Your Ref: OWPC21989
Our Ref: LU/81/19/A
Please ask for:
Mr Z Denton

Town & Country Planning (Control of Advertisement) (England) Regulations 2007 (as amended)

1 No. illuminated logo sign with halo lit lettering fixed to wall on front elevation.
Lovelong House 18-22 East Street Littlehampton

Visual at 10% scale

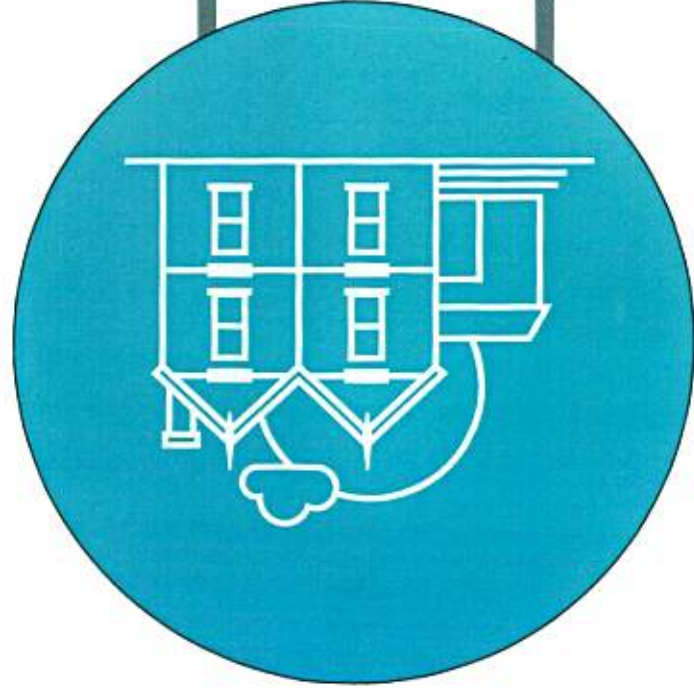
The Town Council's Planning and Transportation Committee considered this matter at its meeting on Monday 1st April 2019 and objected to the application. On the grounds that the proposals would have an adverse effect on the character and appearance of the East Street Conservation Area by virtue of their size, design and the materials proposed. The illuminated "Halo" signage was also in conflict with the local Planning Authority Supplementary Guidance regarding Advertisements and the guidelines for advertising in Conservation Areas.
